DATE: 29/06/2015

West Sussex County Council was consulted previously on highway matters for this site under application AL/114/12 for the erection of 4 dwellings on land to the land adjoining Sunnyside. No anticipated highway safety or capacity concerns were raised to this proposal. This latest consultation response seeks to deal with plans and details submitted pertaining to conditions 3, 4, 5, 7, 9, 12, 13, 15 & 16

APPLICATION NO: AL/46/15/DOC

Registered: 12-MAY-15
Site Address: Land adjoining Sunnyside Westergate Street Westergate PO20 3QR

Job Number: 1558	Drawing Number: 100	Revised: <table><tr><td></td><td></td><td></td></tr><tr><td></td><td></td><td></td></tr></table>						
Drawing Scale: 1:500 (A3)	Date: Nov 12	Drawn: P.J.L. <table><tr><td>Checked:</td><td></td></tr></table>	Checked:					
Checked:

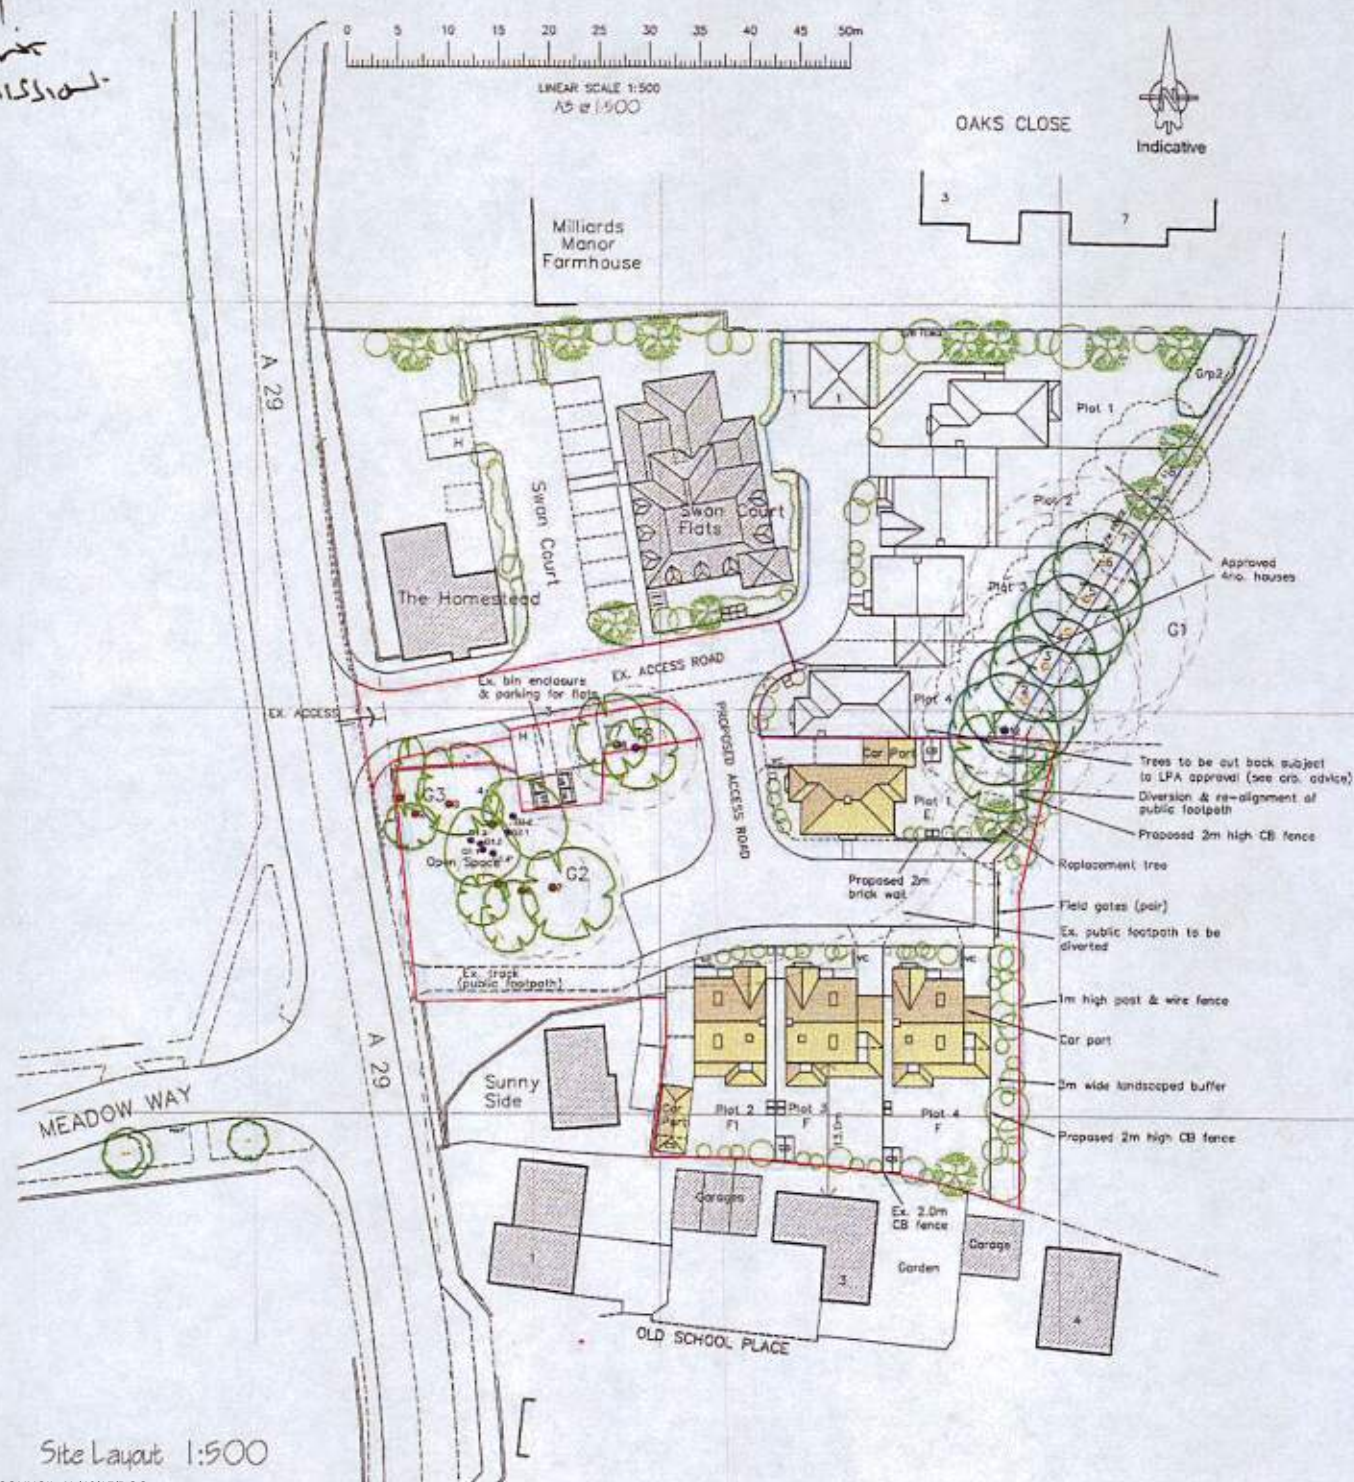
A plan has been provided (1558-100) detailing the site set up during construction. The details of this plan are considered acceptable from the Highways Authority perspective.
